Rezoning Transportation Analysis

Petition Number: 2022-199

Date	Description
4-27-23	First Review (TM)
05-24-23	Second Review (TM)

**SCHEMATIC
 SITE PLAN**

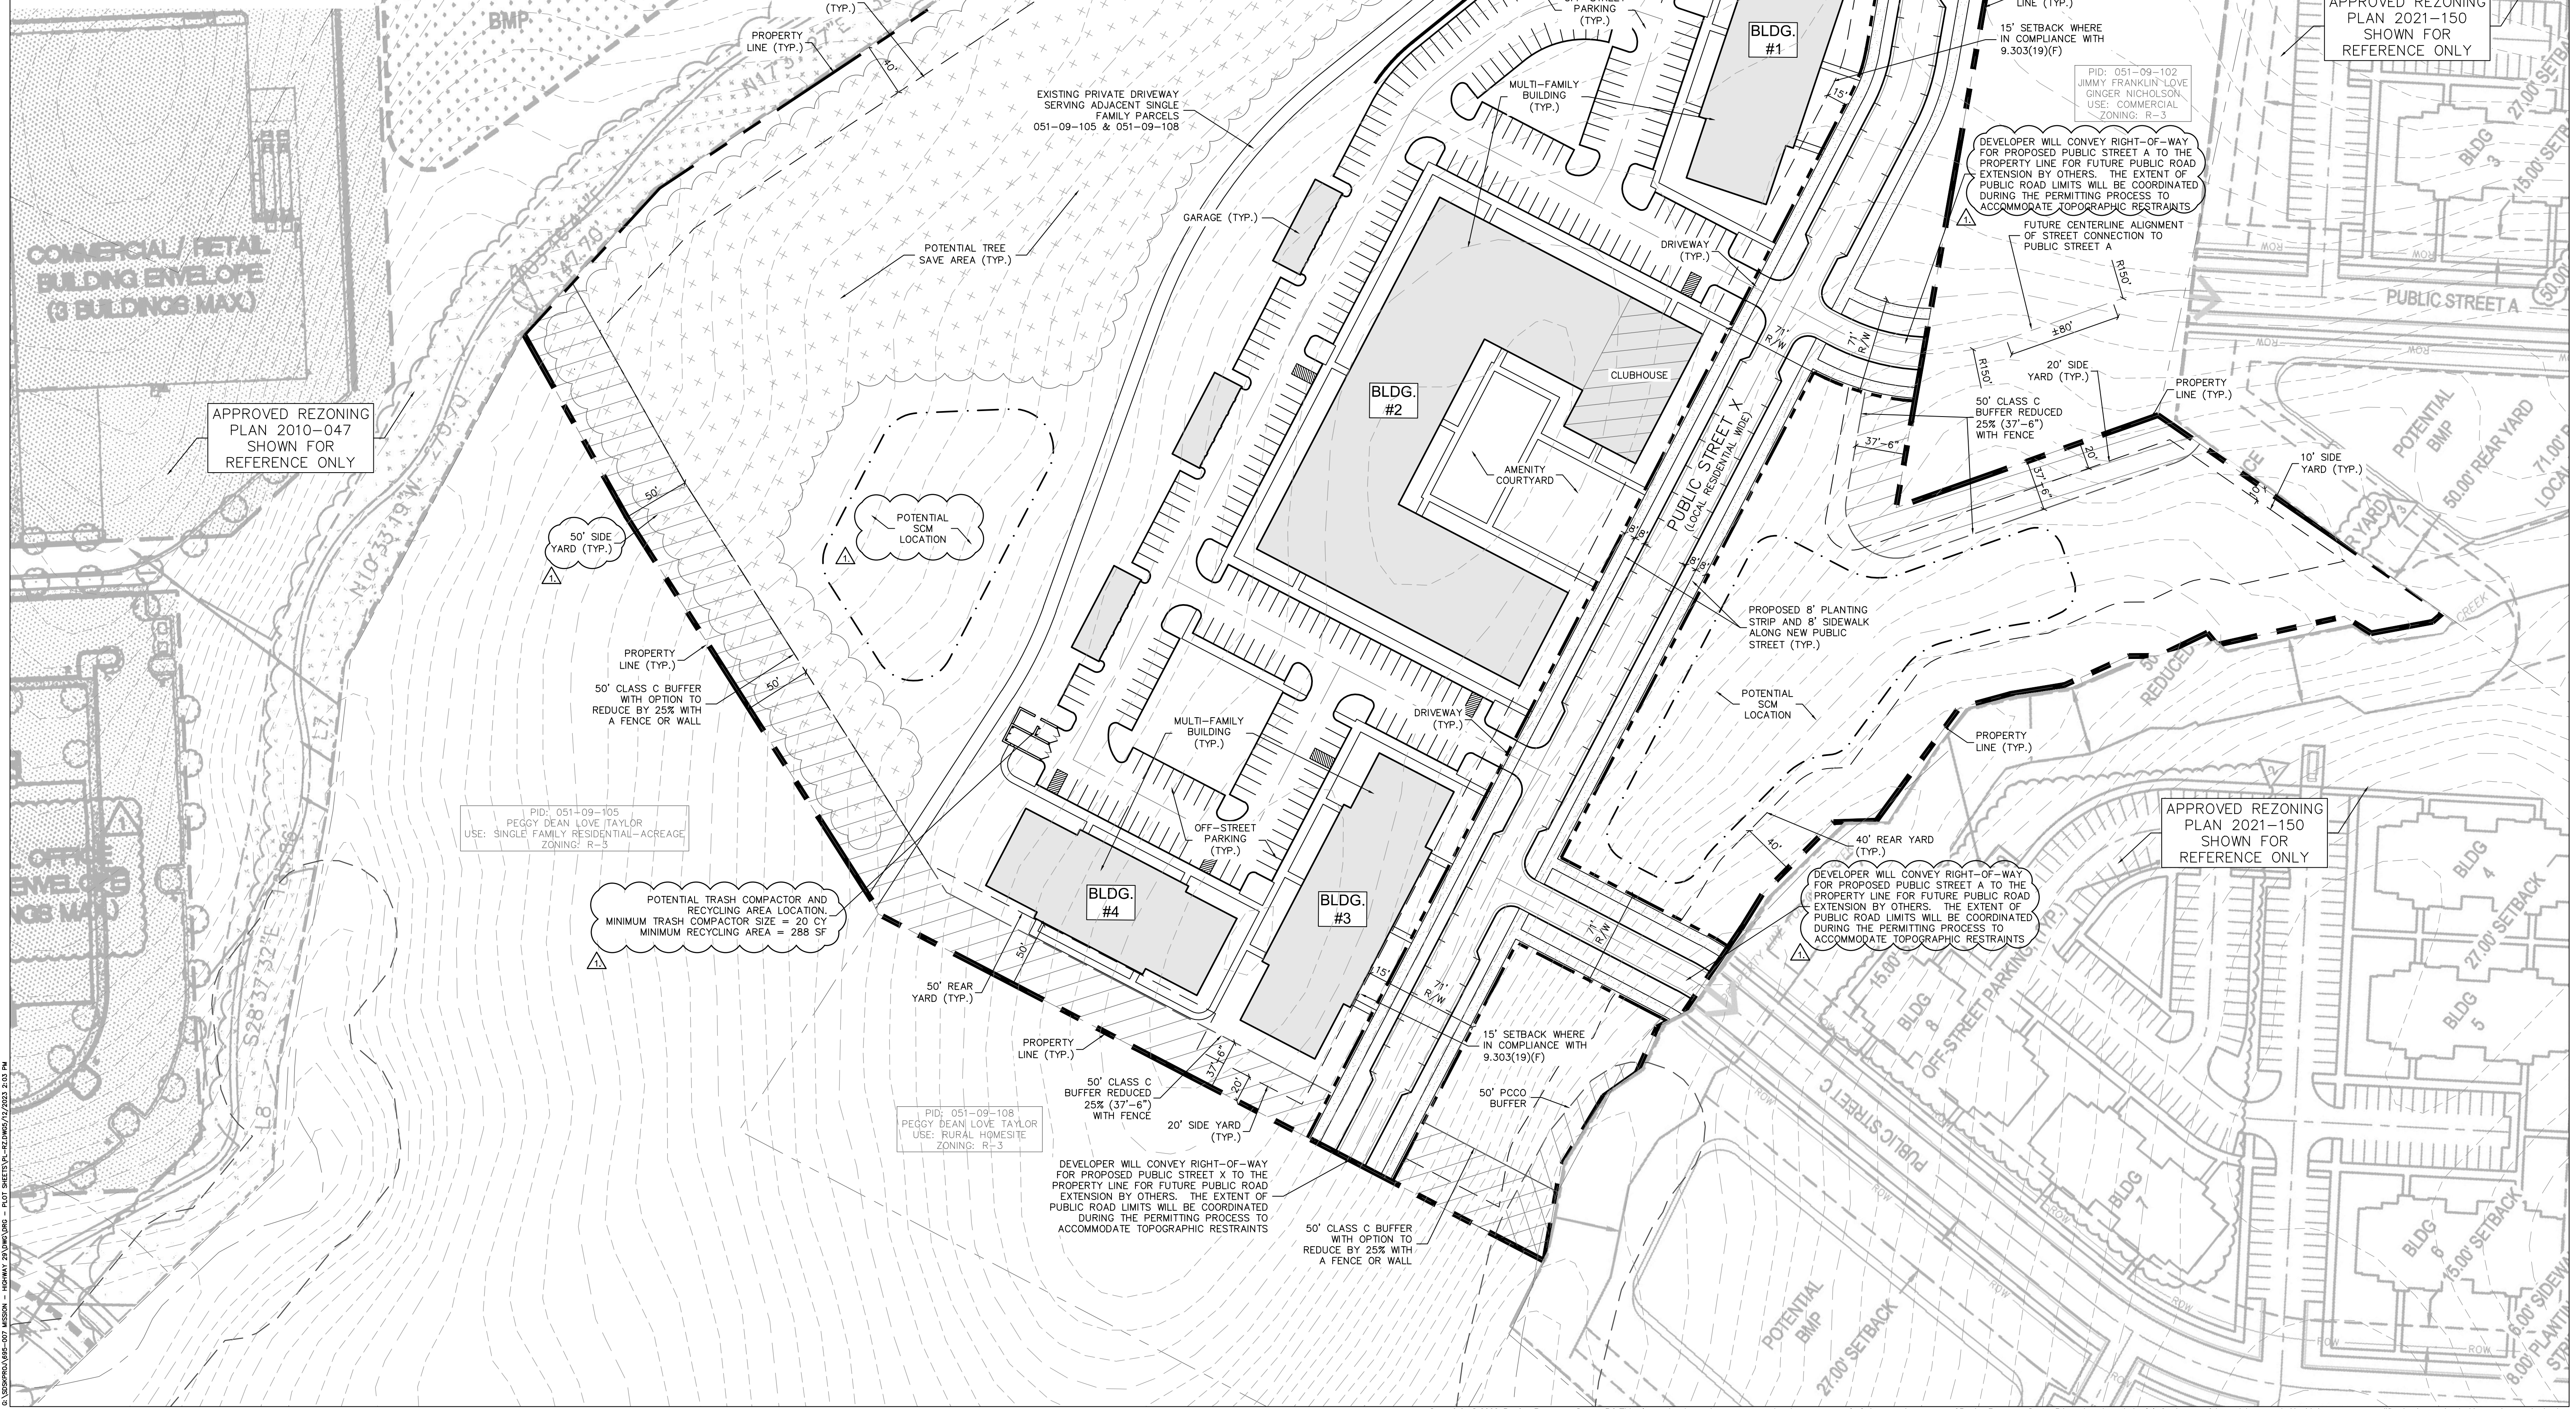
1. Curblines:

- a. ~~US 29 Highway:~~ Location of curb and gutter to be moved to 44 feet from roadway centerline to accommodate the Charlotte Streets Map with a roadway typical section of 6+ Boulevard, Shared Use Path.

NOTE: Additional distance from center line to back of curb may be required in locations where a median is present or around intersections and interchanges. Add a conditional note that the final location of the curb line is to be determined during the permitting process.

Label and dimension the curb and gutter from the centerline for each road on the site plan.

8. Add a conditional note specifying "All transportation improvements will be approved and constructed before the site's first building certificate of occupancy is issued. The petitioner may phase transportation improvements if said improvements and phasing are explicitly described in site plan notes."
